# **KITITAS COUNTY**

### **MEMORANDUM**

TO: All Staff  
FROM: Justin Turnbull, County Surveyor  
DATE: April 15, 2022  
SUBJECT: County Survey Review of BL-22-00005 Cooke

SHEET 1 OF 2

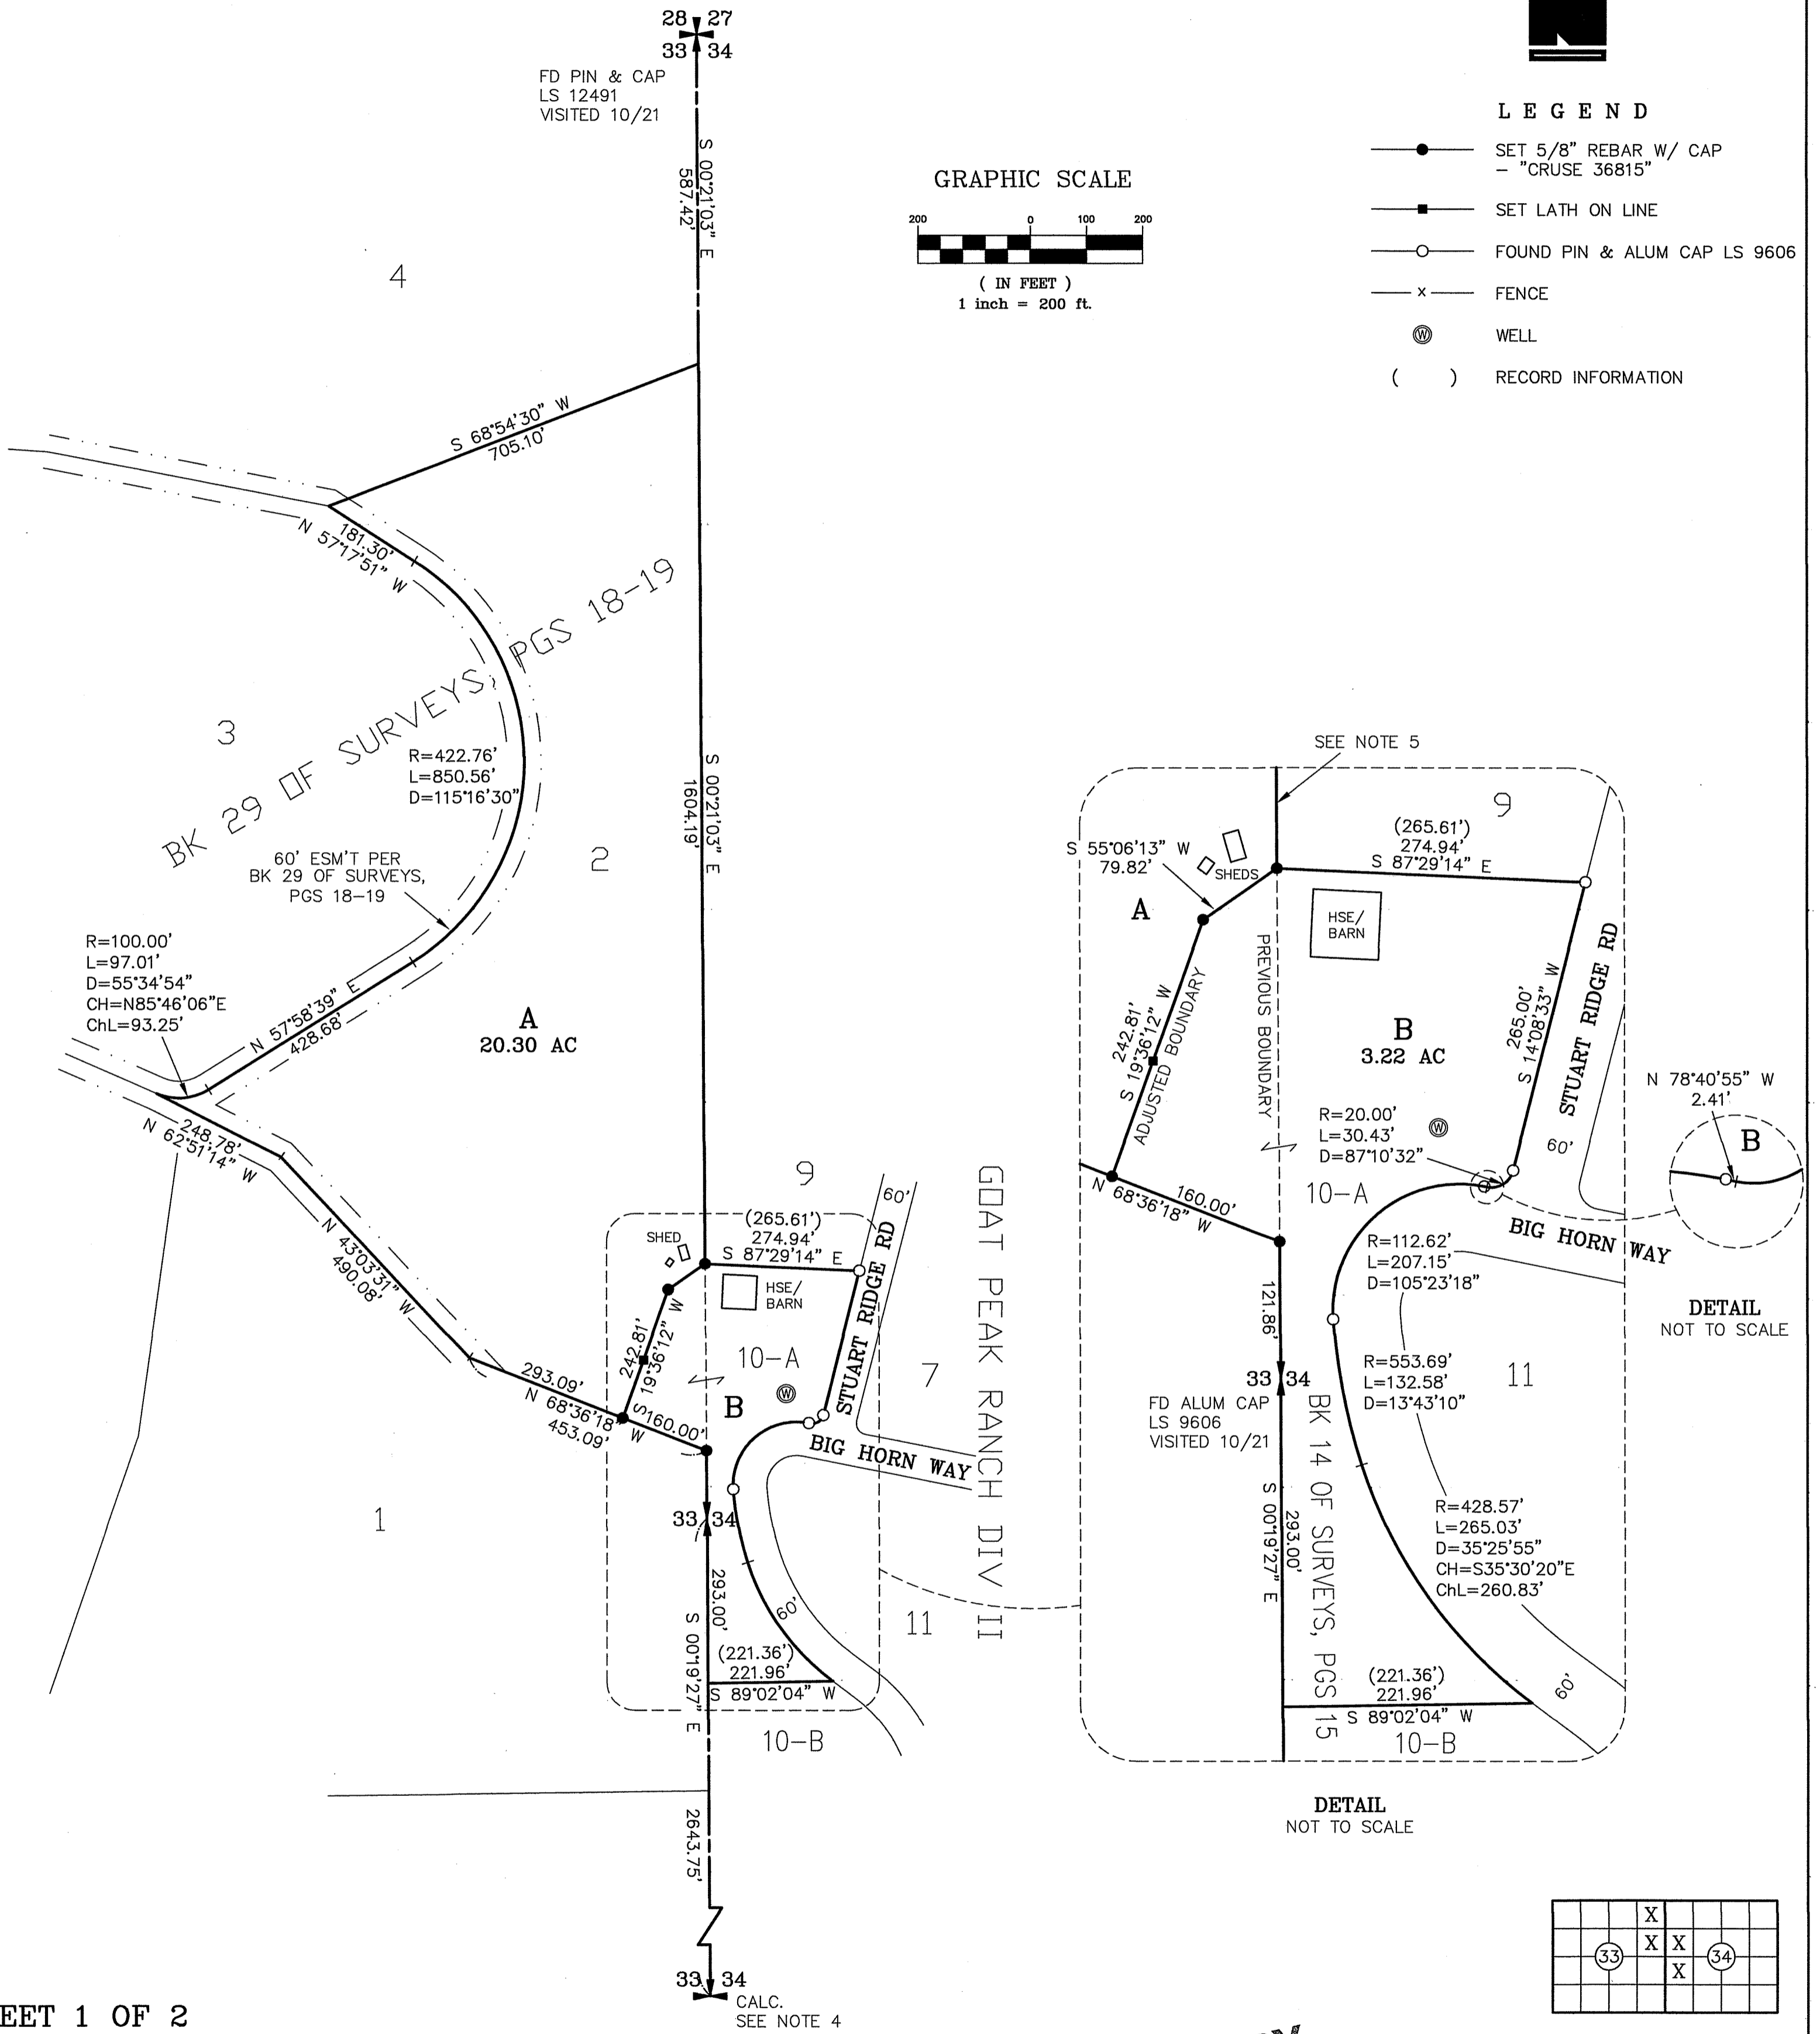
1. All references to "Bk 29 of Surveys, Pgs 18-19" should be changed to "Bk 29 of surveys, Pgs 187-188".
2. Please include ownership (private/County/state) and surfacing for all roads shown.
3. Please include the bearing for the 121.86, long line segment along the West line of Lot B.
4. As the south line of Lot B has a different distance in the deeds as well as the recorded Survey, you may want to note what records reference the distance in brackets.
5. The location heading at top of page contains an extra comma.
